Application by National Grid Electricity Transmission for an Order Granting Development Consent for the Sea Link Project

Comments from Saxmundham Town Council arising from the Issue Specific Hearing 1 (ISH1) on the scope of the development held on Tuesday 11 November 2025.

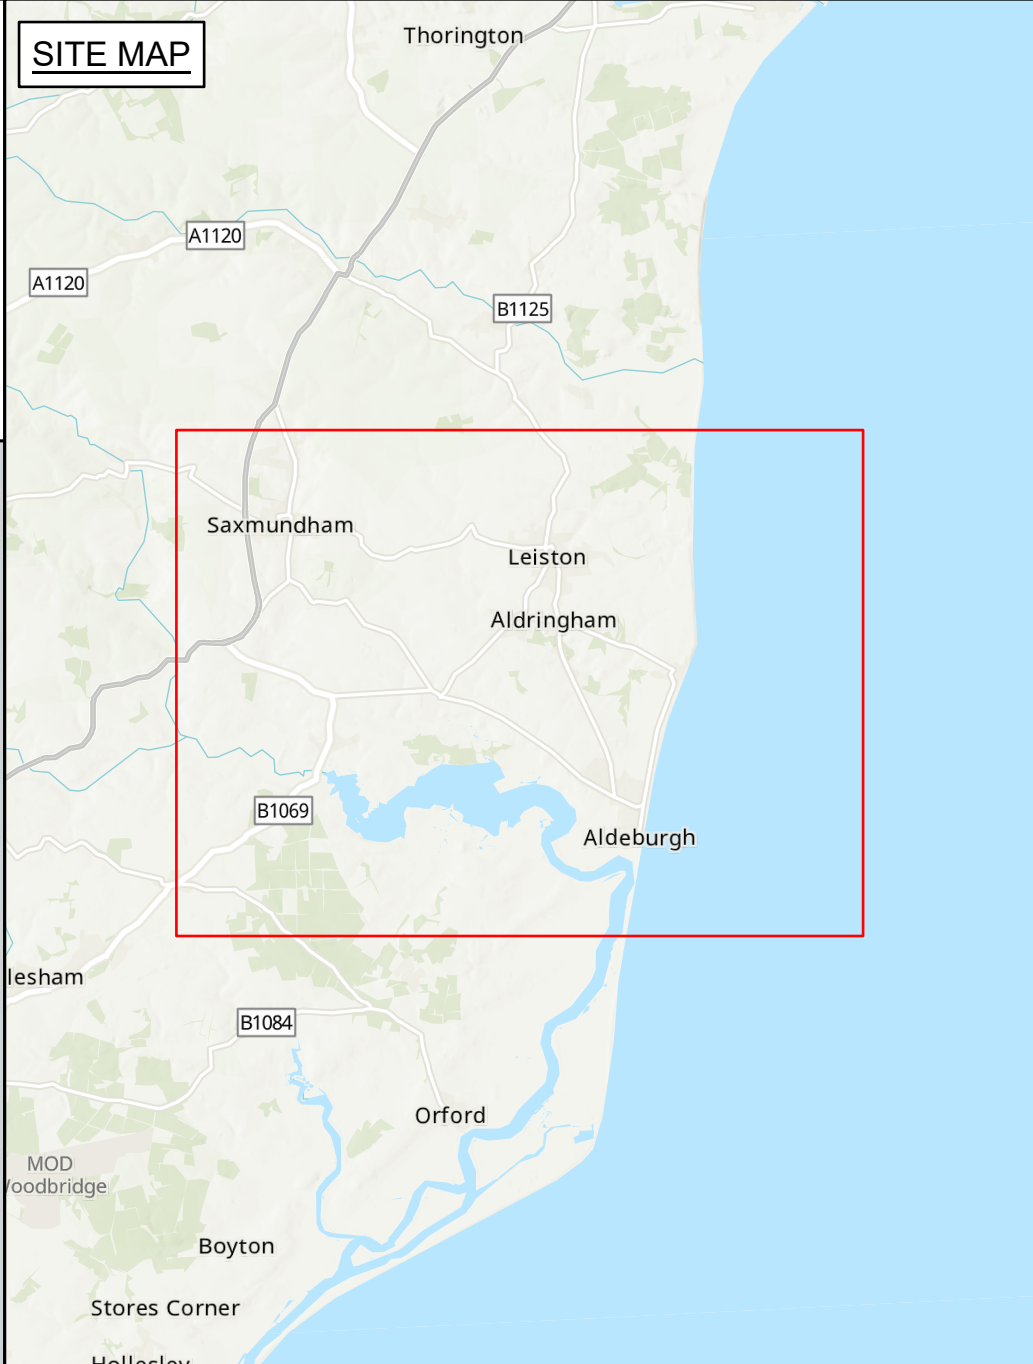
We thank the ExA for questioning the Applicant concerning use of the land indicated white on sheet 1 of 6, [2.14.1 Indicative General Arrangements Plans - Suffolk \(planninginspectorate.gov.uk\)](#). We specifically refer to the area between compounds S02 and S03 and the B1119. Due to the proximity of this land to Manor Gardens, and the associated disturbance to residents should it be developed, we would like to understand the reasoning for inclusion of such a large acreage.

In the absence of development we would welcome environmental mitigations, especially the planting of woodland, as highlighted in our Relevant Representation, Empowering Nature document. [EN020026-000579-Sea Link Relevant Representation - Submission Version Redacted.pdf \(planninginspectorate.gov.uk\)](#). Not only would this benefit the natural environment, but eventually help to screen the Converter Station from the B1119.
